**DRAINAGE LETTER
FOR
19580 FOUR WINDS WAY**

FEBRUARY 2022

PCD FILE NO's:
CDR225

EXISTING DRAINAGE BASINS			
BASIN	AREA (ACRES)	Q5 (CFS)	Q100 (CFS)
OS-1	0.02	0.0	0.1
OS-2	0.14	0.2	0.6
EX1	0.17	0.1	0.5
EX2	0.54	0.2	1.6

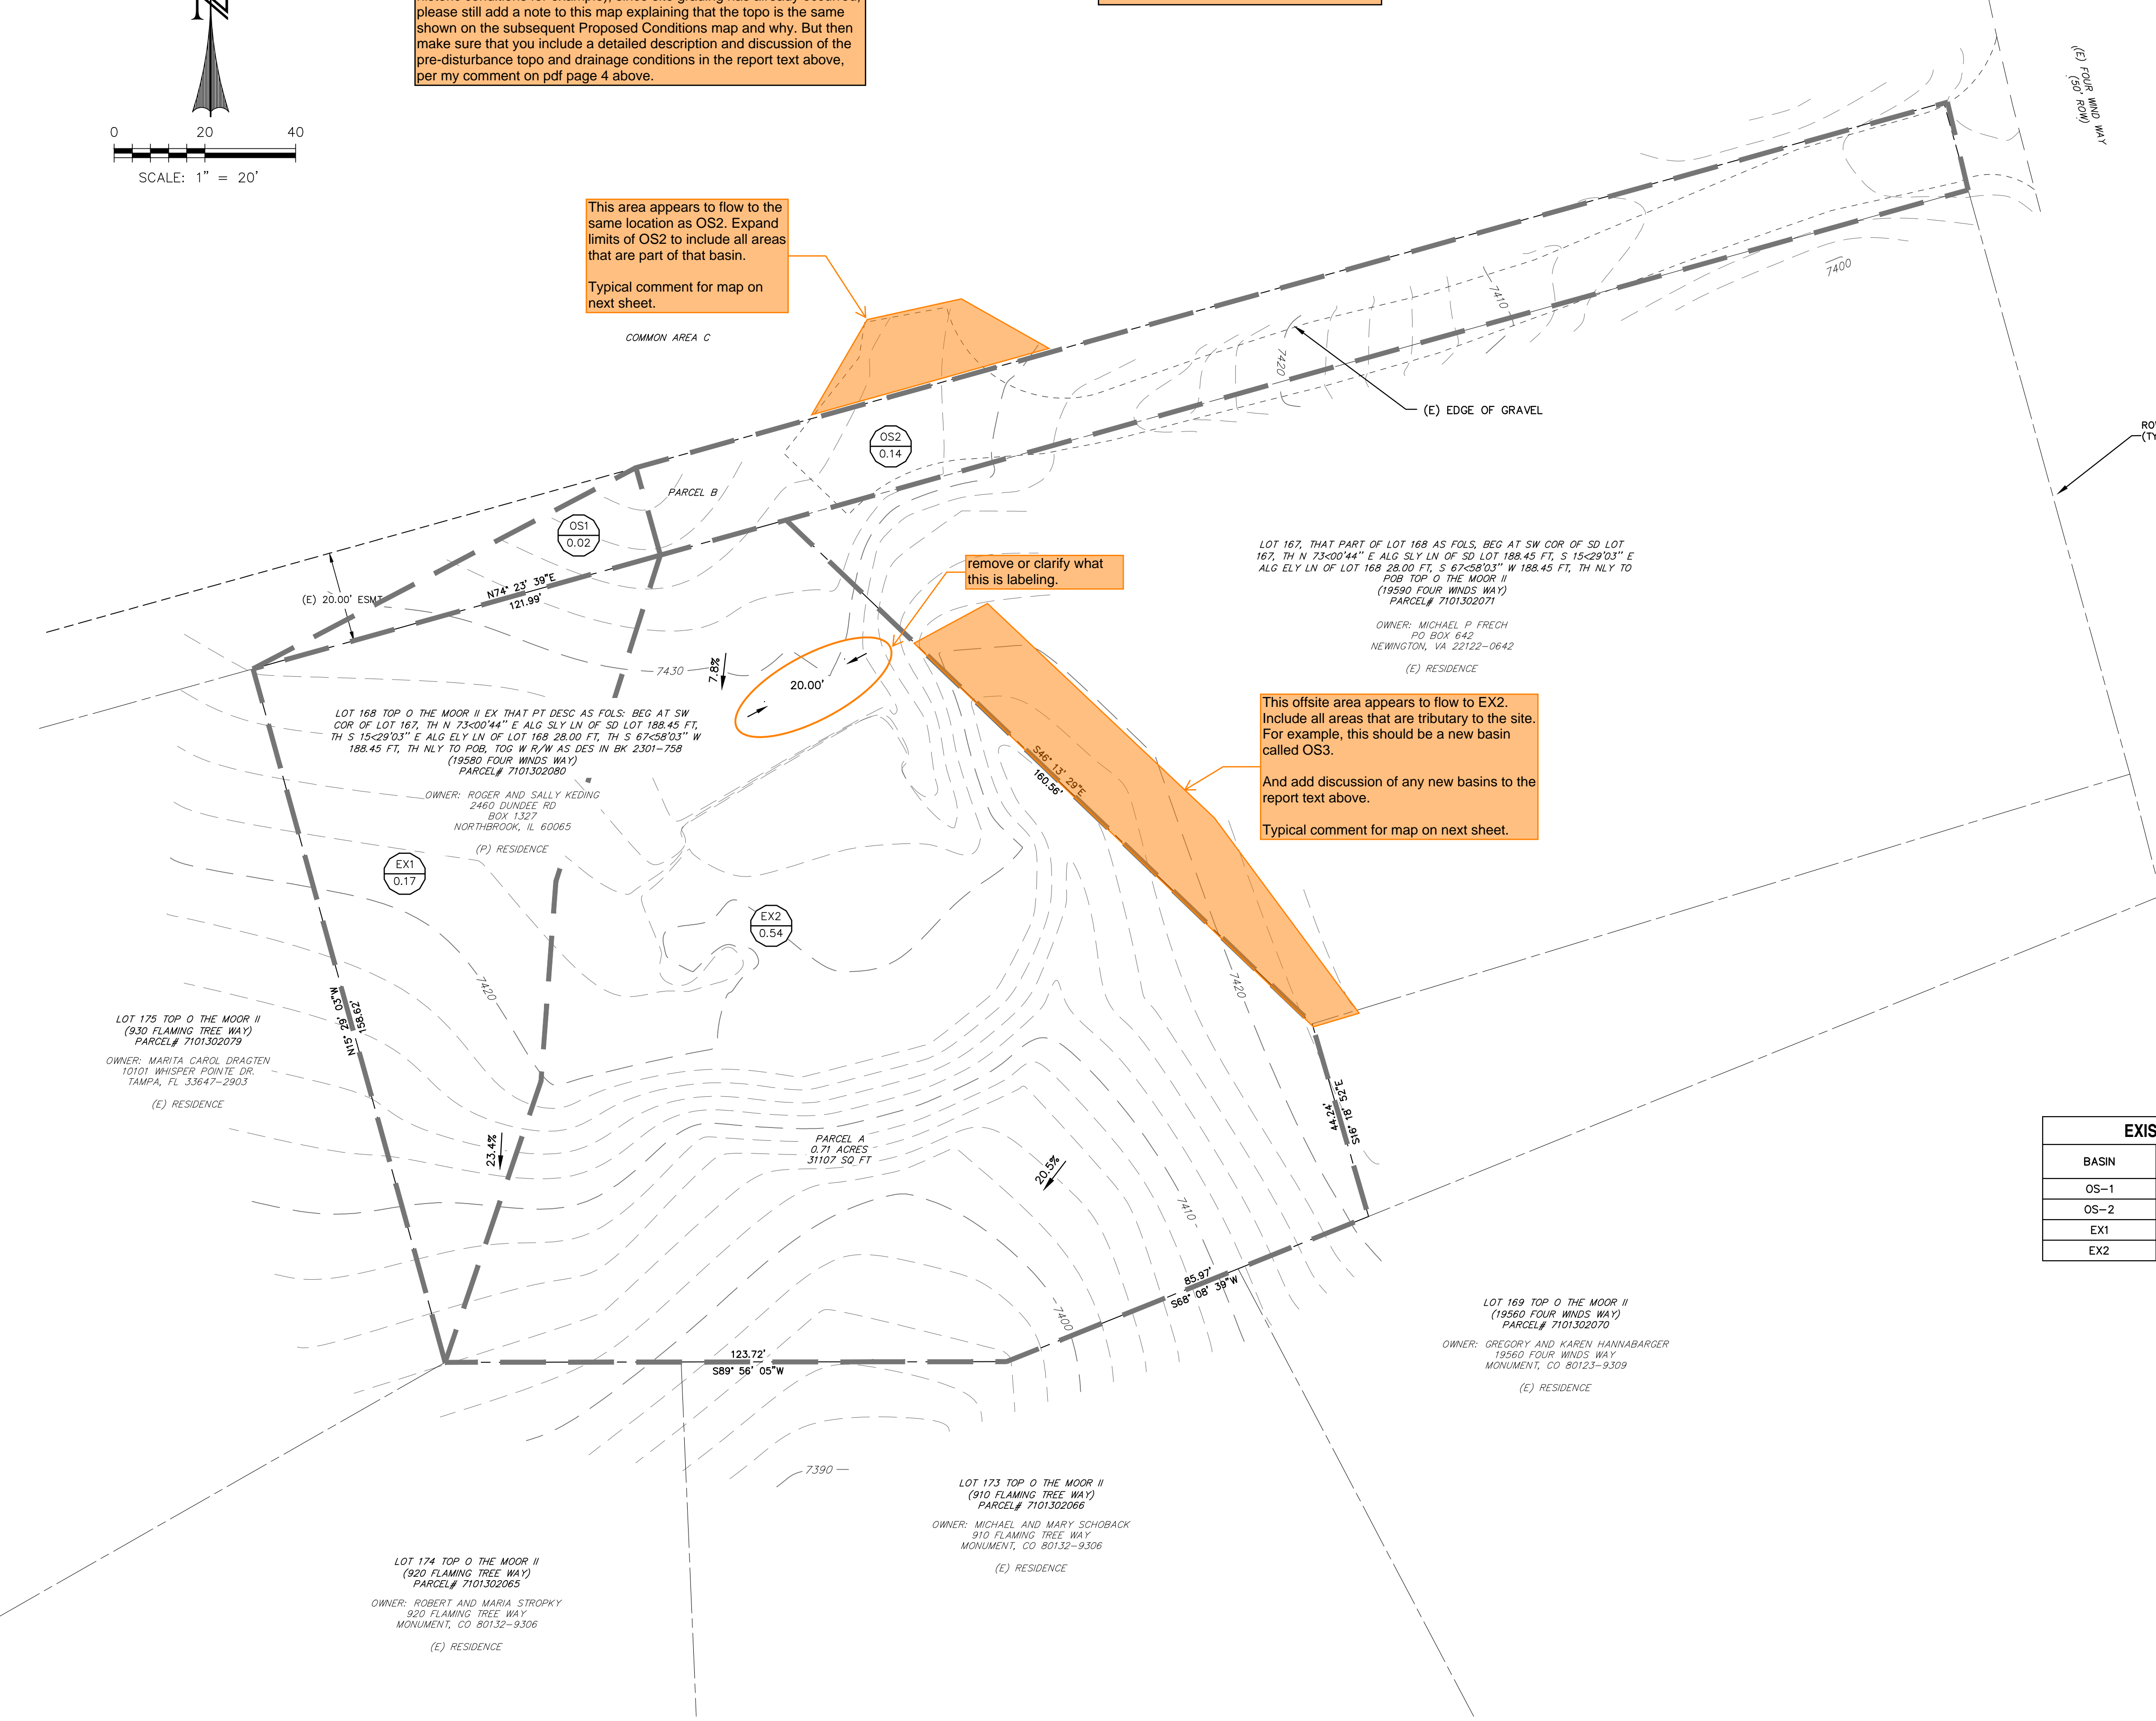
Existing conditions should only discuss the pre-development conditions. We have to pretend that most of the grading for the house has not already occurred. Otherwise Existing conditions will equal Proposed conditions.

Need to add a discussion for Basin OS-3

PROPOSED DRAINAGE BASINS			
BASIN	AREA (ACRES)	Q5 (CFS)	Q100 (CFS)
OS-1	0.02	0.0	0.1
OS-2	0.14	0.4	0.8
A1	0.17	0.1	0.5
A2	0.54	0.5	2.1

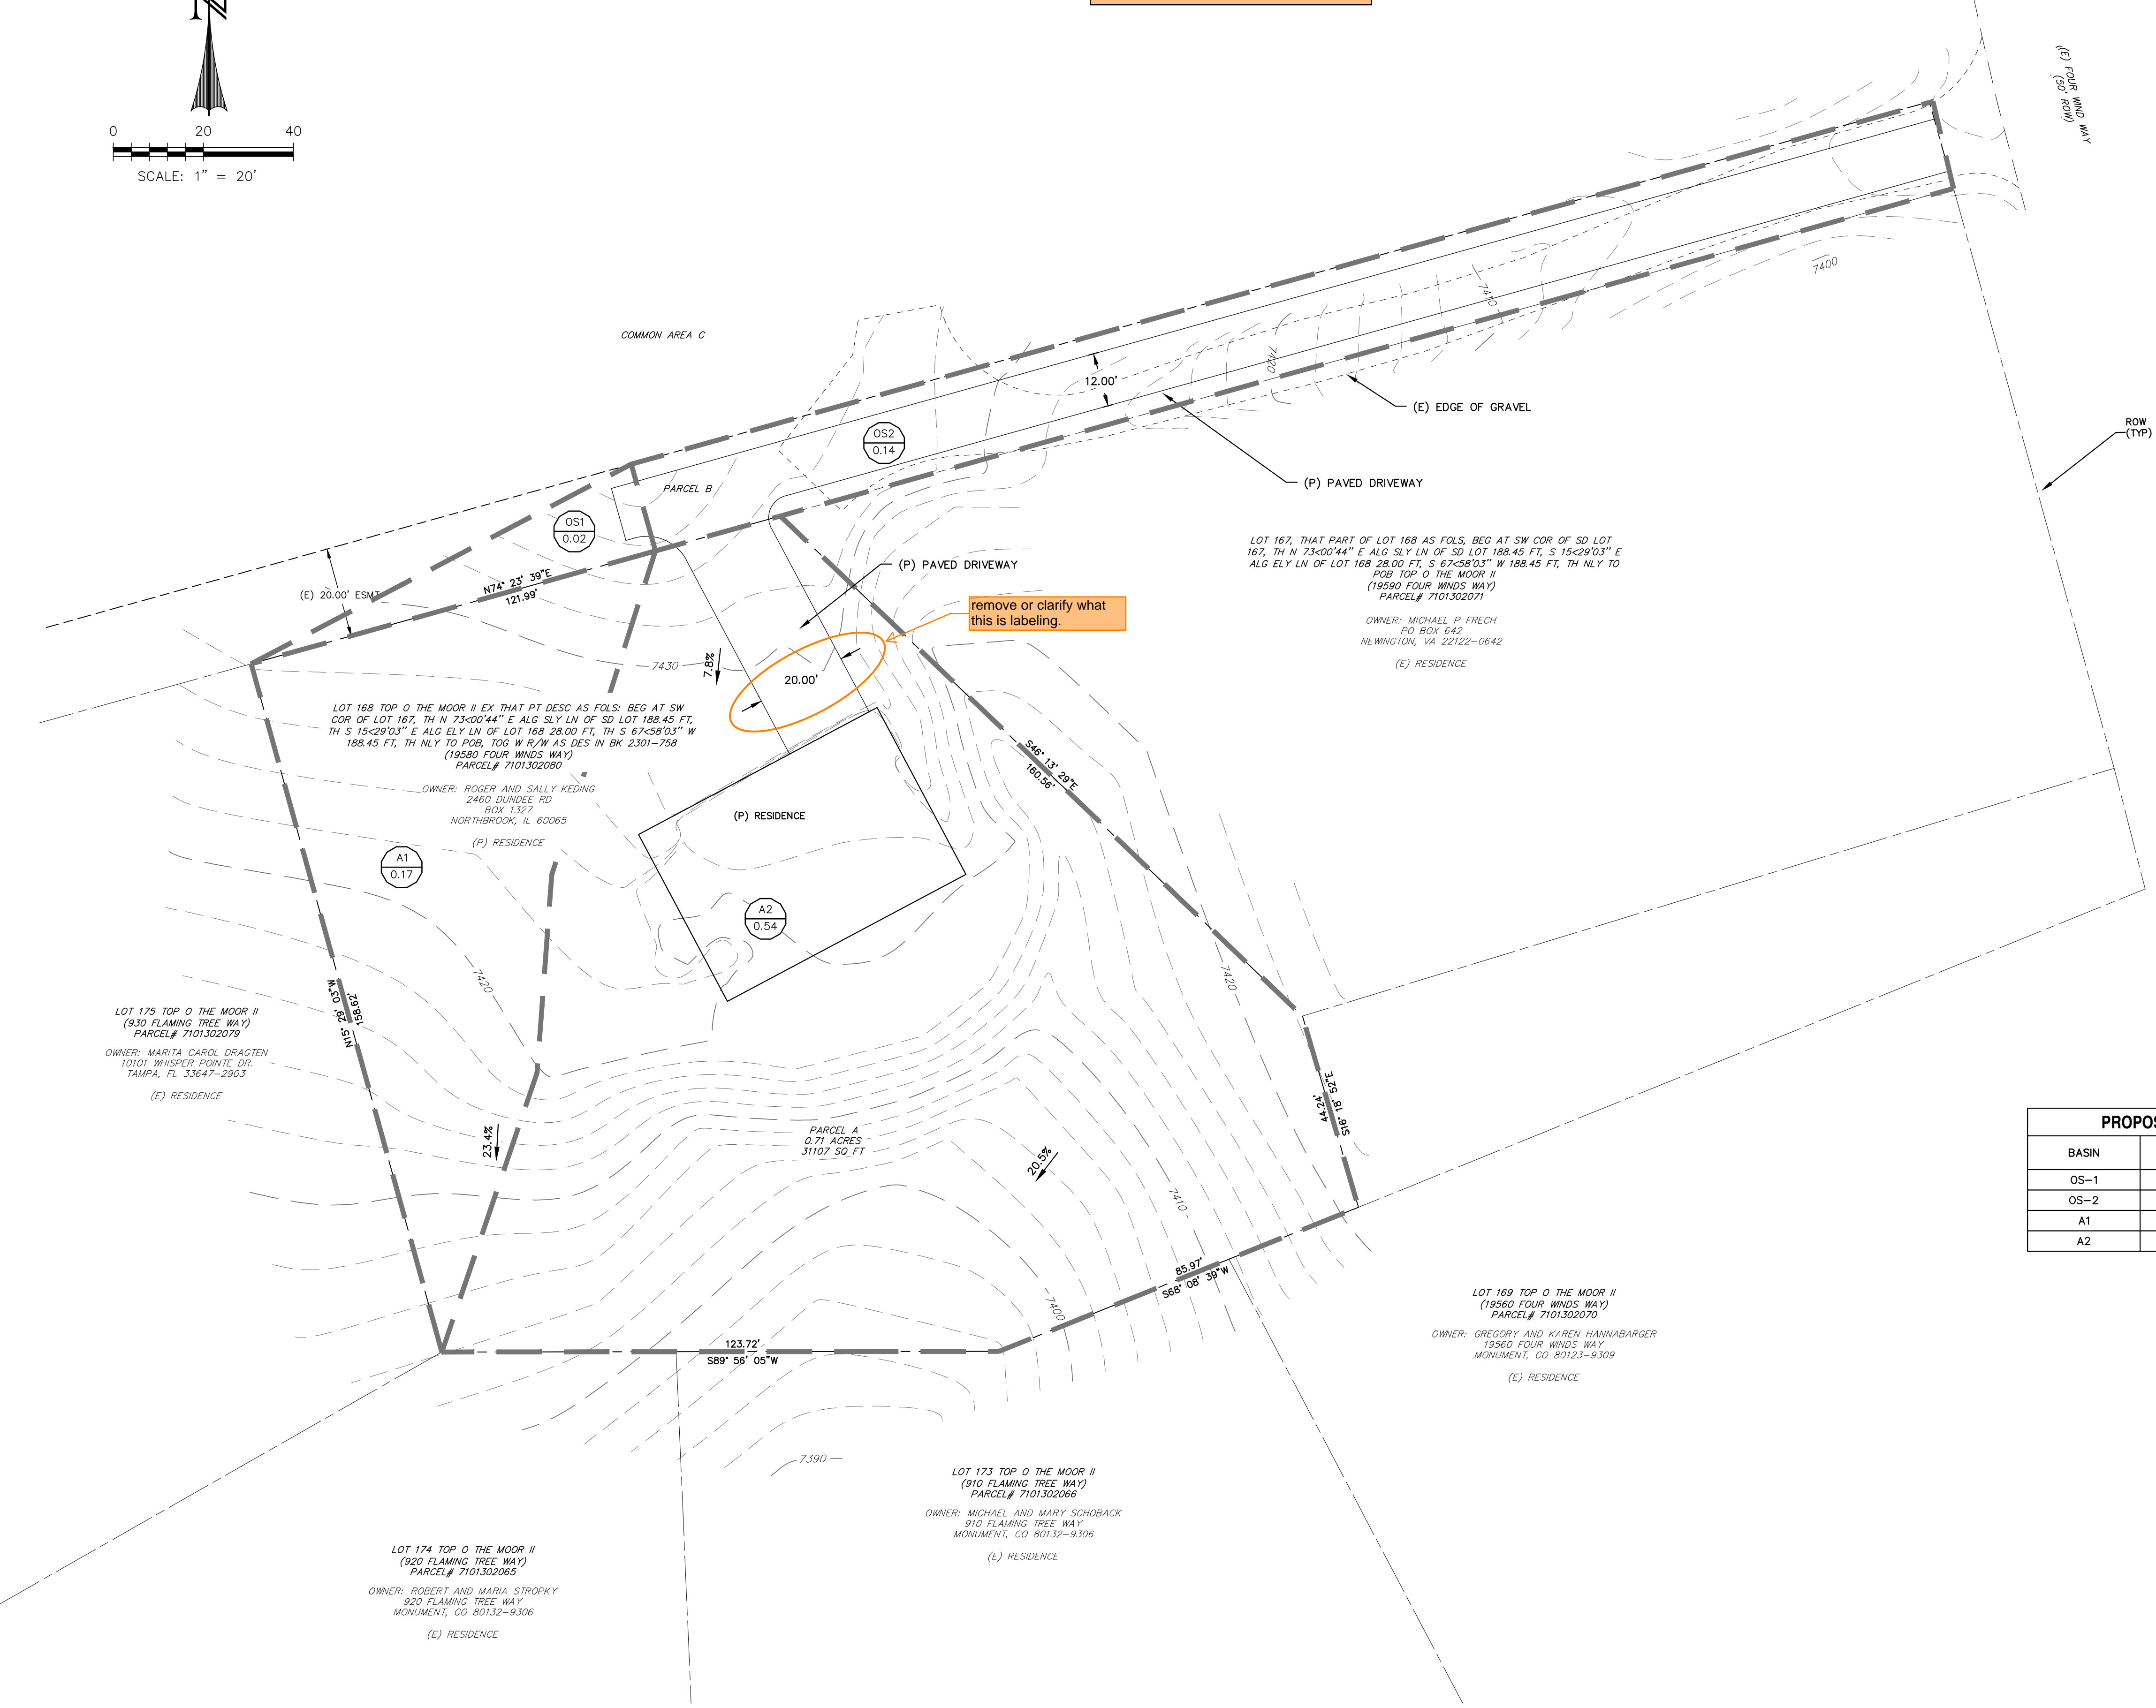
Based on the current topo within the limits of the building footprint, it seems that some additional grading is needed to flatten out the home pad. See comments on drainage map

Need to add a discussion for Basin OS-3
